February 13, 2026

Re: Pedestrian Level Wind Study Addendum
1824 Bank Street, Ottawa
Gradient Wind File 24-150

The City of Toronto provided the applicant, Sun Life Assurance Company of Canada, with the following comments:

DRAWING TITLE:
 BUILDINGS 2
 ELEVATIONS

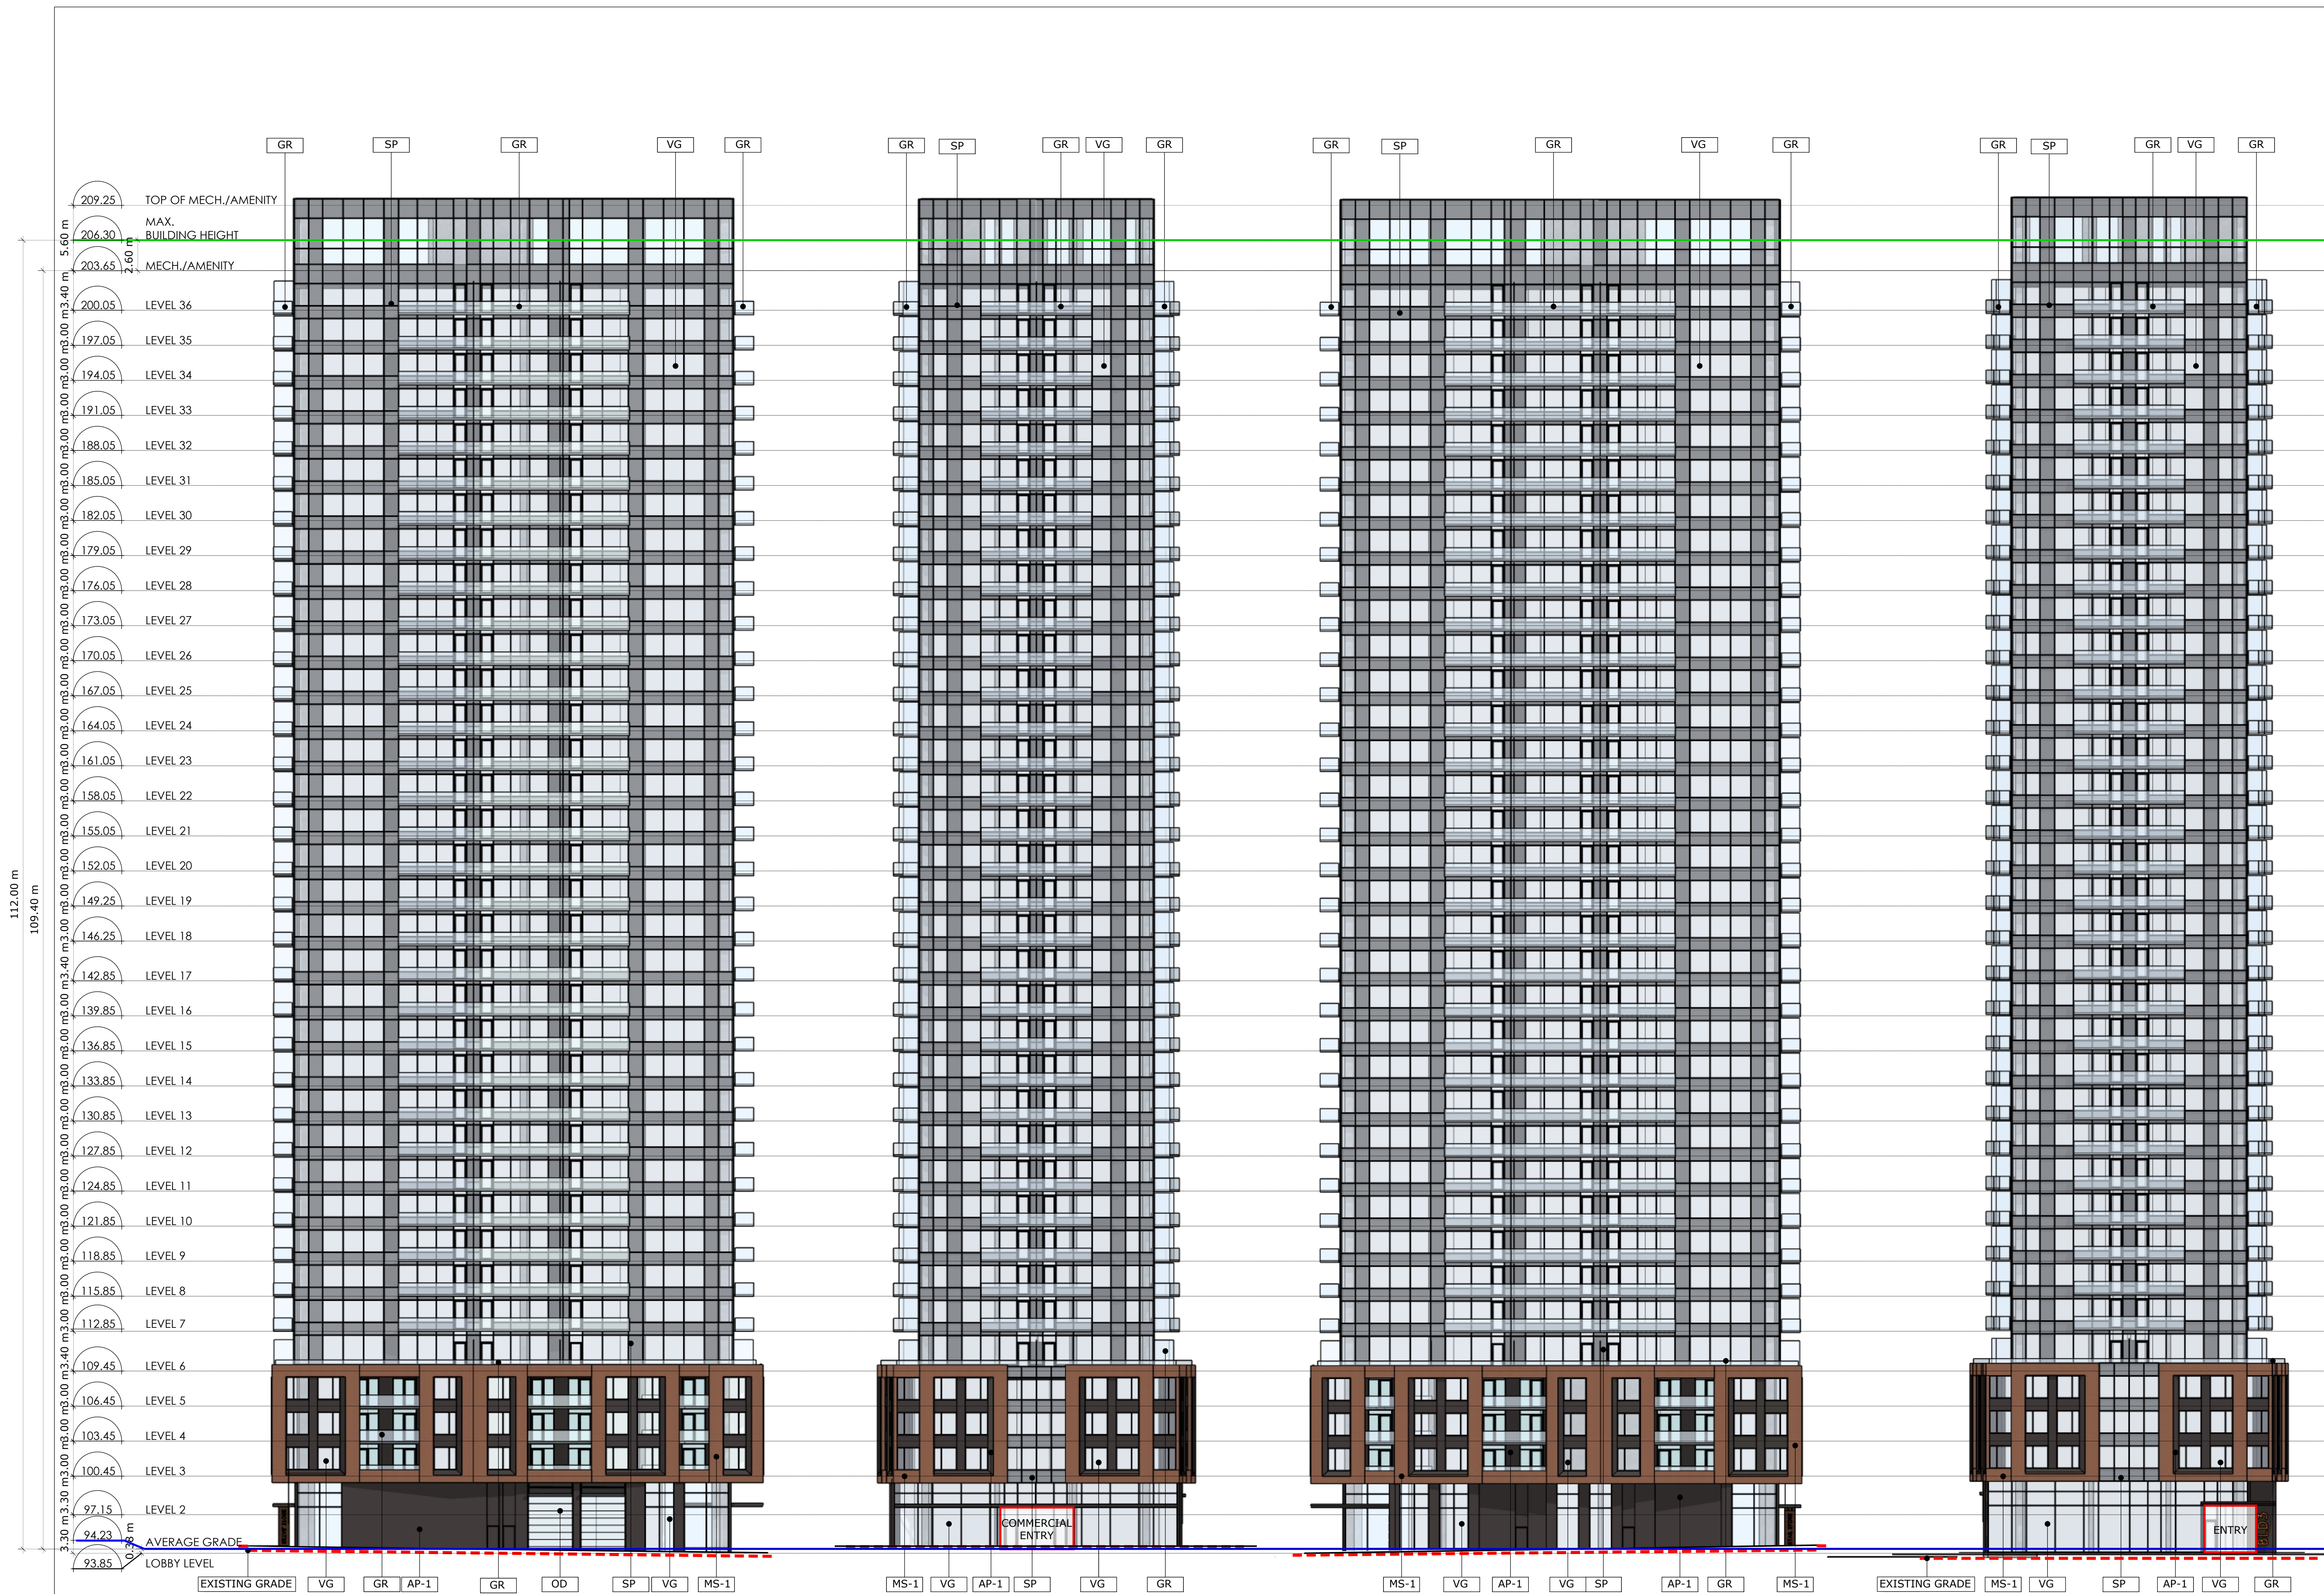
“Uncomfortable conditions in spring, fall, and winter are identified between Buildings 2 and 3, and Buildings 3 and 4. Please confirm what mitigation measures will achieve acceptable conditions. Consideration should be given to adjusting the proposed massing as necessary to improve these conditions.”

Mitigation measures that may improve wind conditions between Buildings 2 and 3 and Buildings 3 and 4 include the targeted placement of additional canopies that extend from select podium facades to deflect downwash and isolated clusters of vertical wind barriers to disrupt accelerating winds that channel between the noted buildings.

Additional elements that may be considered by the design team to diffuse downwashing winds include the implementation of additional canopies extending from the east elevations of Buildings 2 and 3, at least 3 m from the podia façades and that wrap around the northeast corners of the respective podia, as well as a canopy that extends and wraps around the southwest corner of the podium serving Building 4.

Drawing No: RZL1

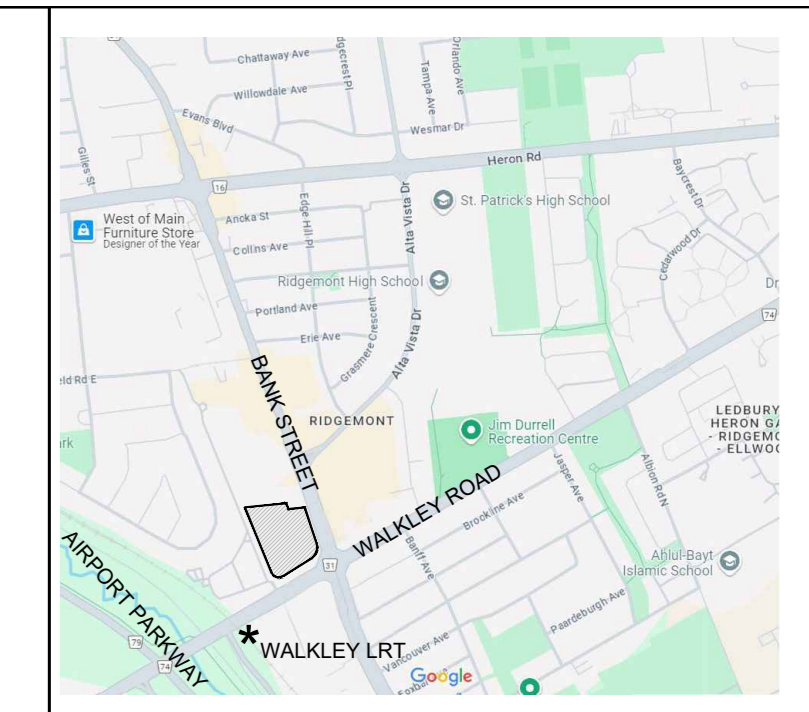
“Only a small area in the new park can be suitable for sitting in the summer. In all other seasons, the park is unsuitable for sitting. How will this be addressed?”

Specifically, isolated wind barriers, such as wind screens, artwork, tall-backed bench seating, cabanas, pergolas with vertical louvered walls, and other similar landscaping elements and treatments may be incorporated within the landscaped area between Buildings 2 and 3. As noted above, several landscaping features have been included in the current landscaping plan to the east of Building 4 and between Buildings 2 and 3. It is recommended that additional landscaping features be included, such as those listed above, and that landscaping elements implemented for wind mitigation be mostly solid and orientated predominantly north-south to be effective at blocking winds channelling through the space. If these features will comprise vegetation, it is recommended that they be coniferous and placed in dense arrangements.

The proposed facility fit plan⁴ includes a combination of tree plantings throughout the park, including along its northern, eastern, and southern boundaries, in combination with play structures and an overhead shade structure. The shade structure and the plantings are expected to provide a benefit to wind conditions during the summer and shoulder seasons. Additional elements that may be considered include canopies extending from the west elevations of Buildings 1 and 4 at Level 2 to diffuse the modest downwash during the warmer months over the tower façades to grade that is then redirected over the

central open space. Wind comfort conditions within the proposed park during the typical use period may be further improved by implementing strategically placed tall wind screens, dense arrangements of coniferous plantings in tall planters, high-back bench seating, and other common landscape elements to deflect and diffuse winds across the space. It is recommended that these elements be predominantly orientated with physical barriers along the south and north perimeters of the open space, owing to the directionality of the winds. Additionally, the mitigation as noted above in response to Comment 30, particularly the vertical wind barriers between Buildings 2 and 3, would be expected to reduce the impact of channelling winds from these buildings on the park during the colder months.
